DECISION DELEGATED TO HEAD OF PLANNING

Application No: H23-0369-22 **Applicant:** Mr N Yardley
Proposal: Two storey side extension, single storey rear extension and car port
Location: 109 Broadgate Whaplode Drove Spalding
Terminal Date: 31st May 2022

Proposed Ground Floor Plan
Scale 1:50

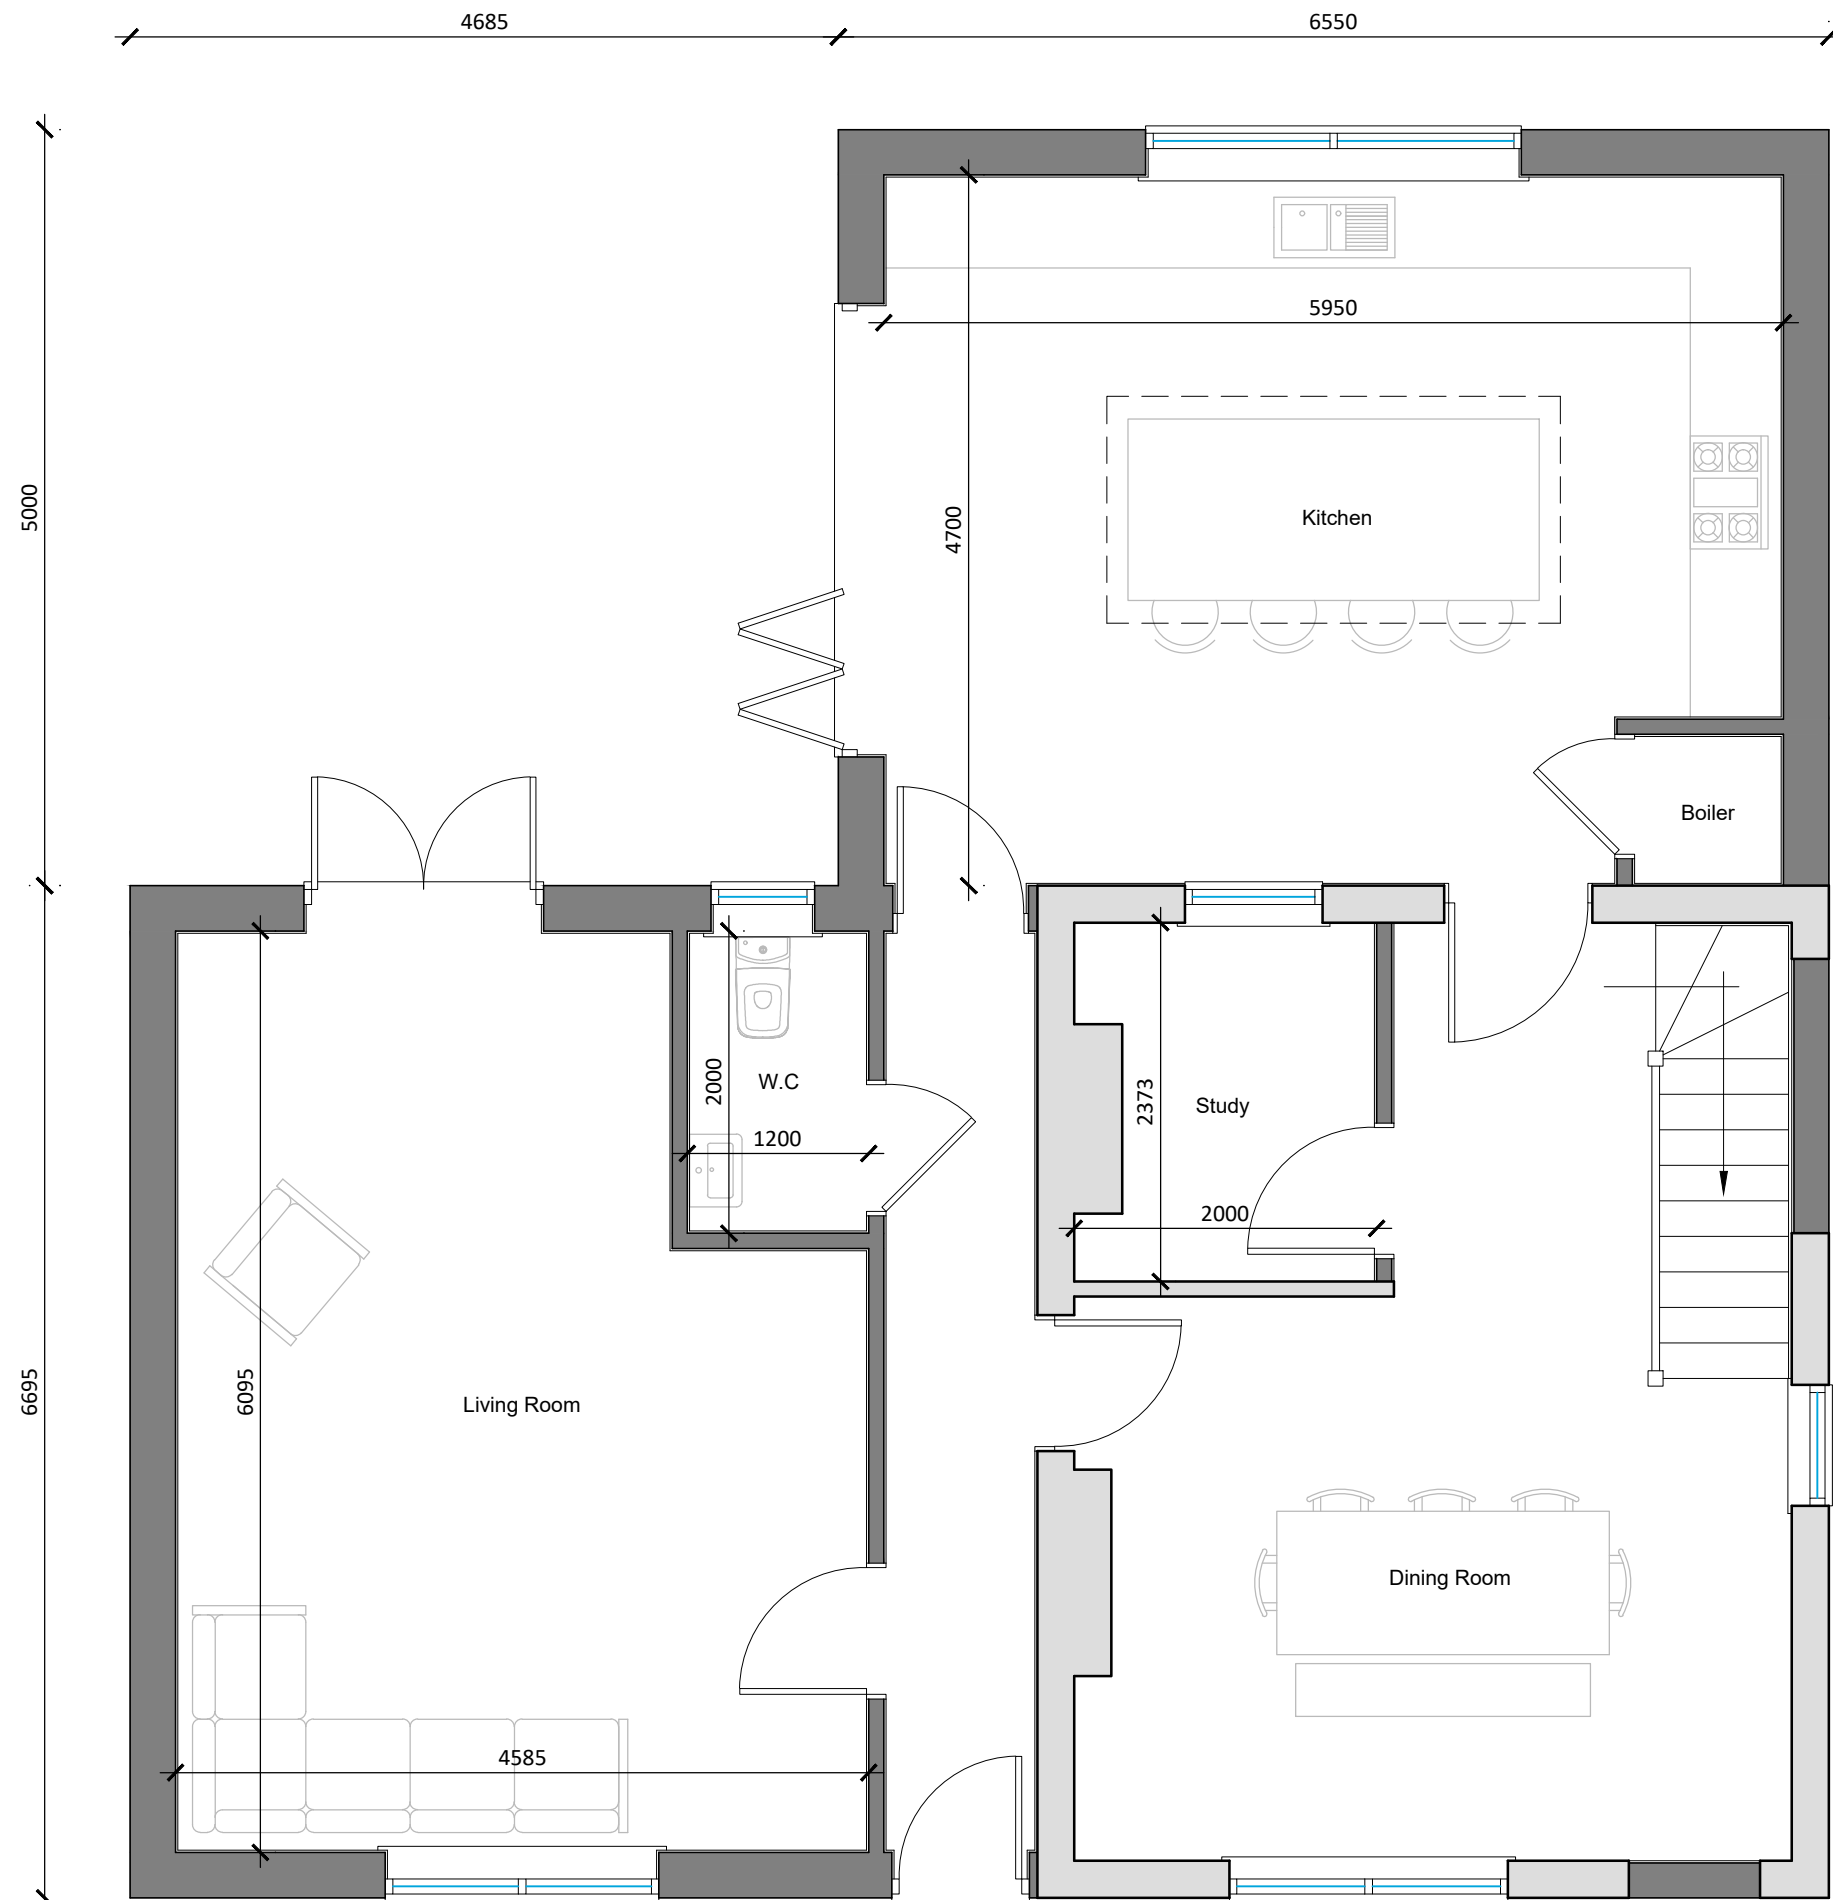
The single storey rear extension would occupy majority of the rear garden, however, the main amenity space for the dwelling is to the front therefore this can be accepted. The scale, mass and bulk of the extension is considered proportionate to the site and the existing dwelling and can therefore be accepted.

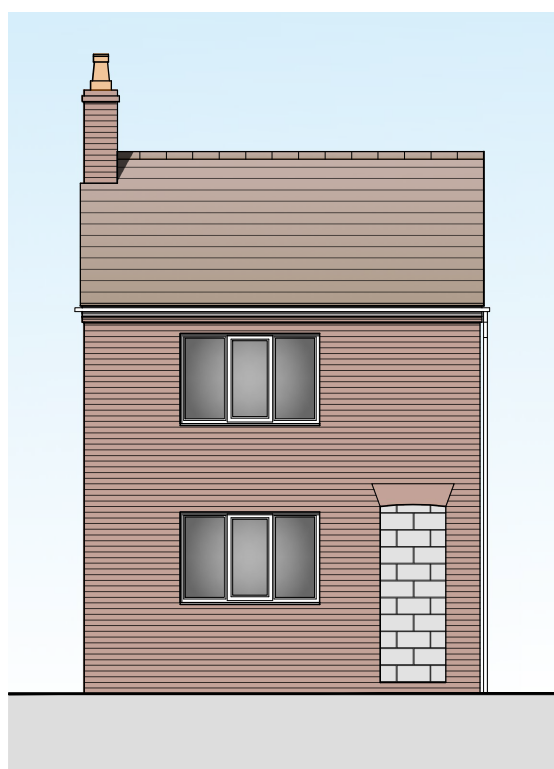
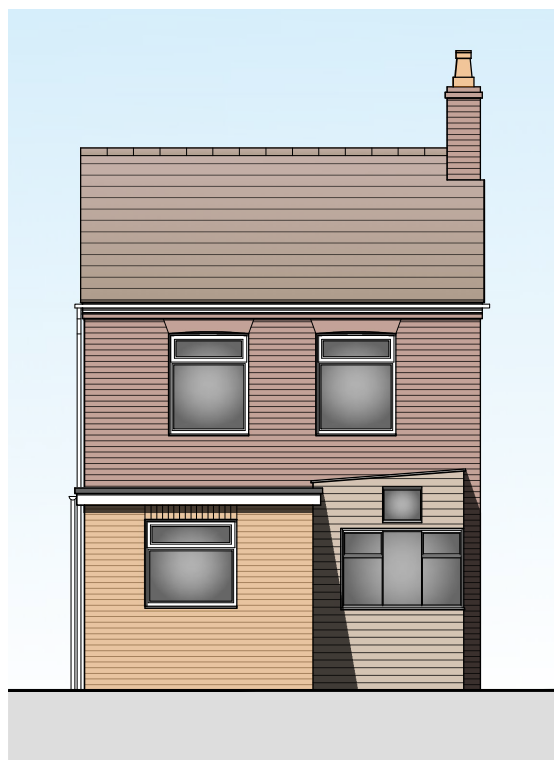
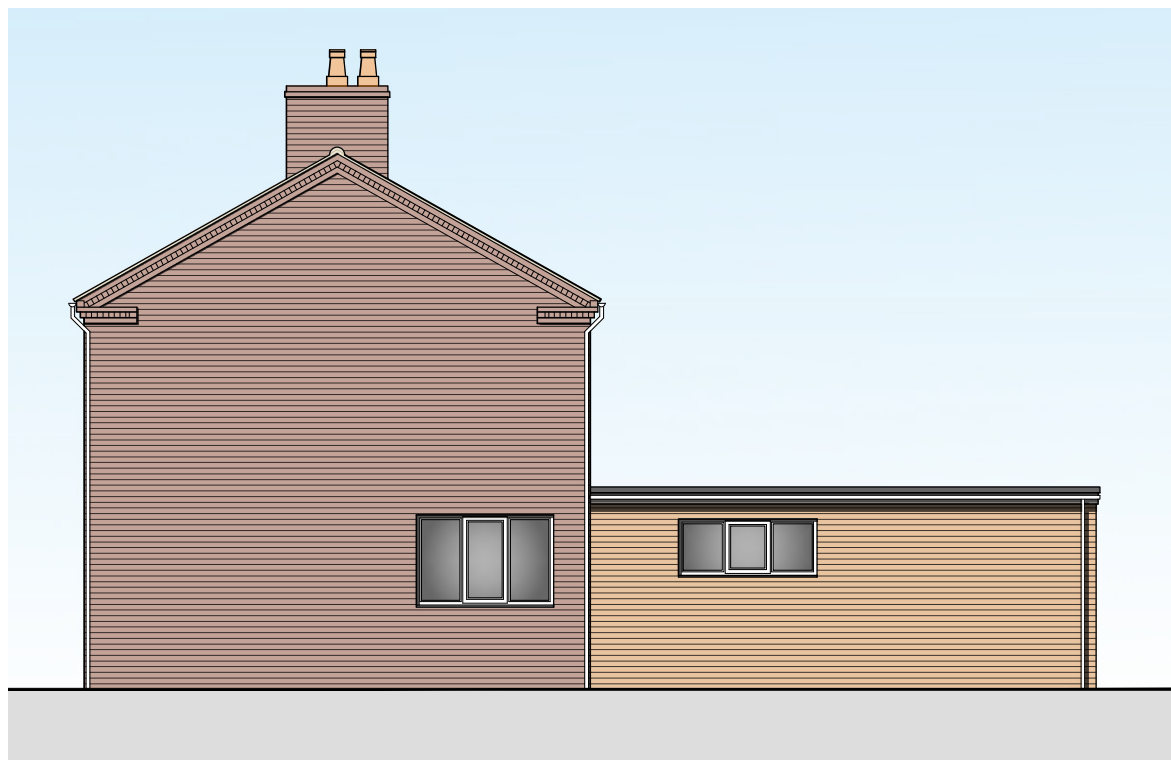
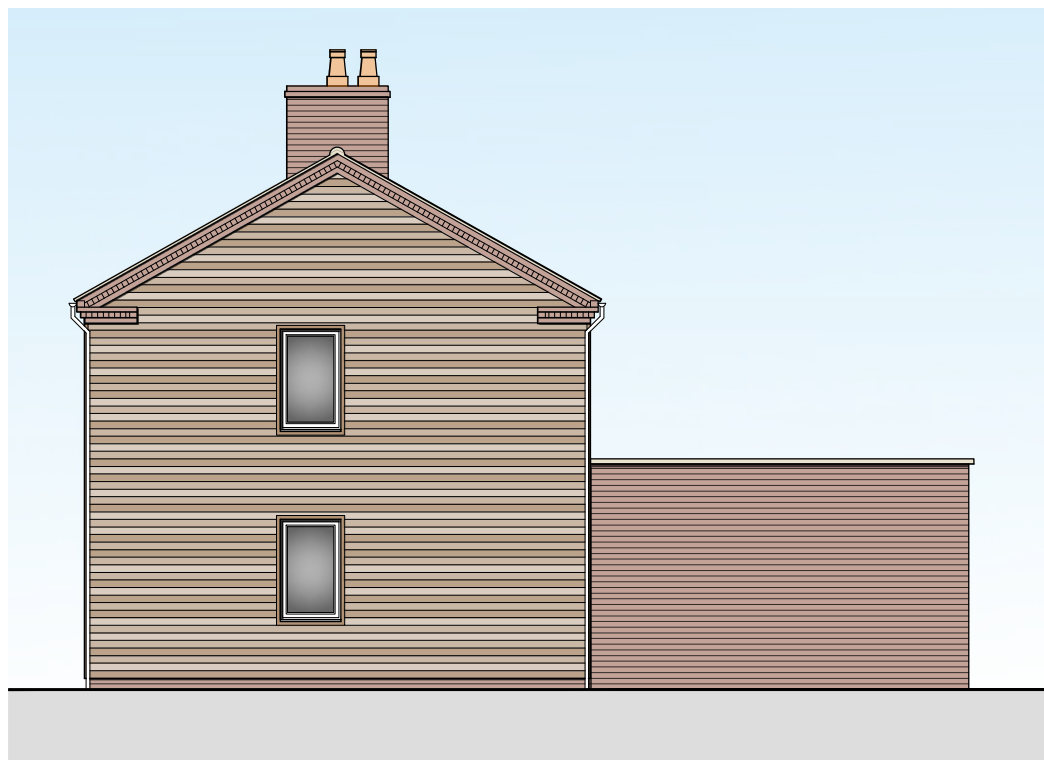
The proposed extensions are considered to be sympathetic in design and proportionate to the existing dwelling. Whilst it is accepted side extensions are usually required to have a lowered roof ridge than the existing, in this instance a flush finish can be accepted given the detached character of the dwelling and the separation distance from the neighbouring property. As such it would not

result in a terracing effect. The proposed use of cladding is considered acceptable given the semi-rural character of the area and examples of various materials in the street.

The closest neighbour to the proposed development is no.111 Broadgate located to the south-west of the application site. This neighbour has requested that any windows overlooking this property should be obscure glazed. The concerns are noted, however, the ground floor window proposed in the side elevation facing this neighbour would not offer any prominent views as there is an existing boundary fence. The proposed first floor landing window in the side elevation facing this neighbour would sit adjacent to this neighbour's blank side elevation therefore it is not considered that any unacceptable overlooking or loss of privacy would result. The two storey rear extension would not be visible to this neighbour as it would not extend beyond the front/rear elevations of the existing dwelling. The proposed rear extension would be sited close to the shared boundary with this neighbour, however, given its single storey nature and the fact it would be sited adjacent to this neighbour's outbuilding no overbearing impact would result. In addition given the orientation of the property no overshadowing would result. The garage would be sited between 14 and 16 metres from the shared boundary with this neighbour. Given this separation distance unacceptable impact is considered to result from this.

With regards to the neighbour to the north-east at no.107 Broadgate the proposal would bring the application dwelling 6 metres closer to this neighbour. The two storey element would be sited 6 metres from the shared boundary with this neighbour and approximately 10.2 metres from its nearest elevation. Given this separation distance no unacceptable overbearing impact is considered to result. Furthermore no first floor windows are proposed in the side elevation facing this neighbour therefore there are no overlooking or loss of privacy issues. The ground floor rear extension would be sited approximately 11 metres from the shared boundary with this neighbour therefore no overbearing impact or unacceptable overshadowing would result from this. With regards to the garage this would be sited close to the shared boundary with this neighbour, however, given the relationship with this neighbour, the limited height of the garage and the fact the pitch of the roof would face away from this neighbour no overbearing impact would result.

| PROPOSED GARAGE FLOOR PLANS & ELEVATIONS      |              |               |            |

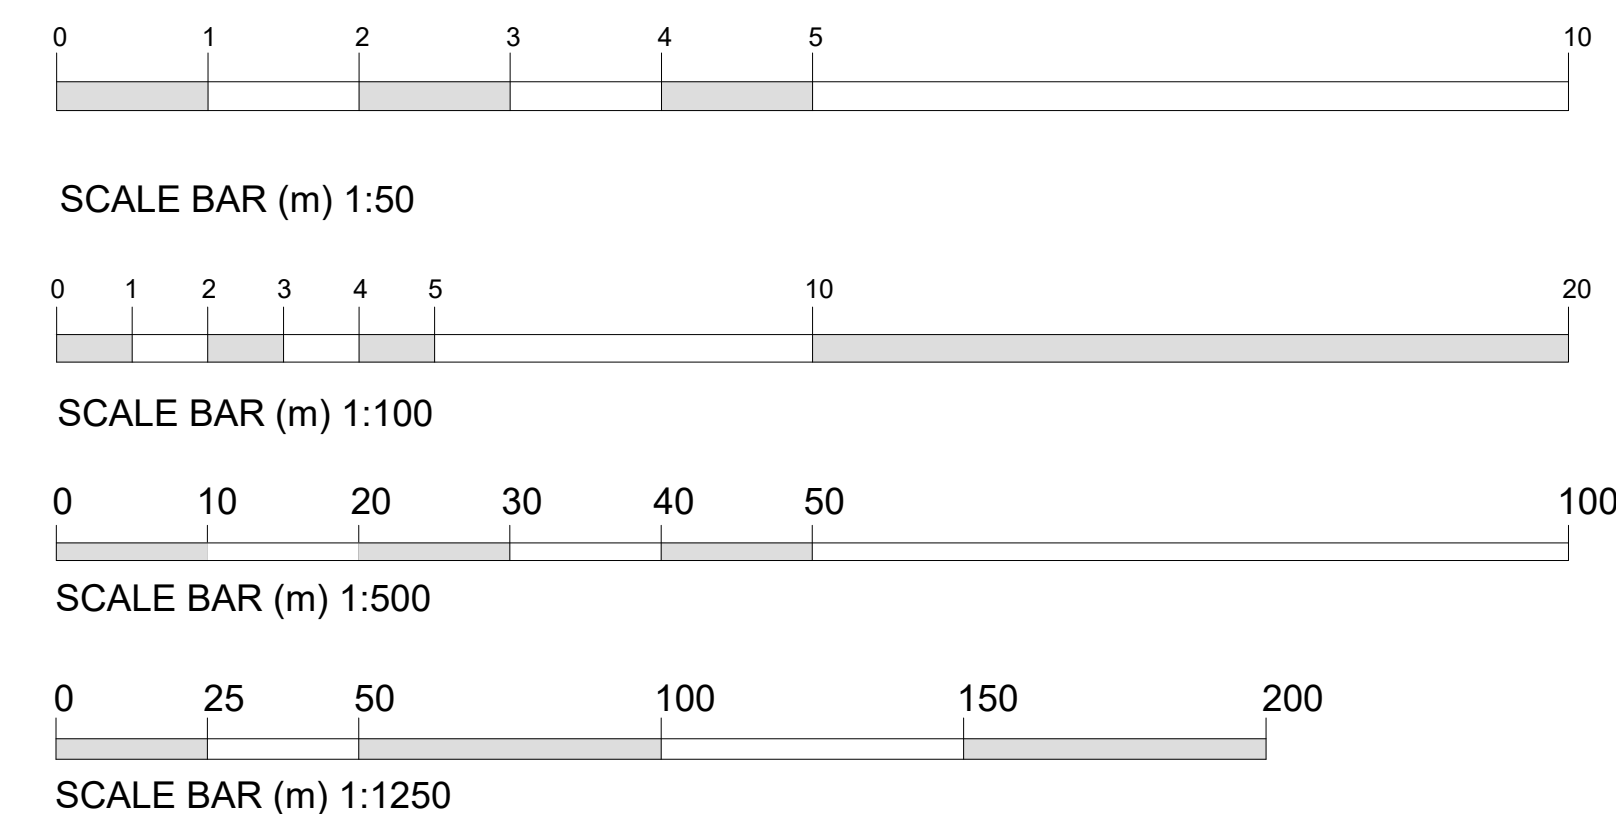
The proposed garage would be sited approximately 10 metres from the front boundary therefore it would not appear overly prominent in the street scene. The materials would match the main house therefore it would be in keeping with the main house. In addition the street scene is varied therefore the proposed structure in the front garden is not considered to be at odds with the street scene.

In connection with Policy 36 of SELLP 2019, Appendix 6 sets out the minimum requirements for car parking provision. The proposed scheme would increase the number of bedrooms in the property from 2 to 4, increasing the parking requirement for the site from 2no spaces to 3no. The proposed garages would meet the size requirements for enclosed parking spaces and there would be additional space in the driveway to the front. As such the scheme is considered to comply with the current parking standards.
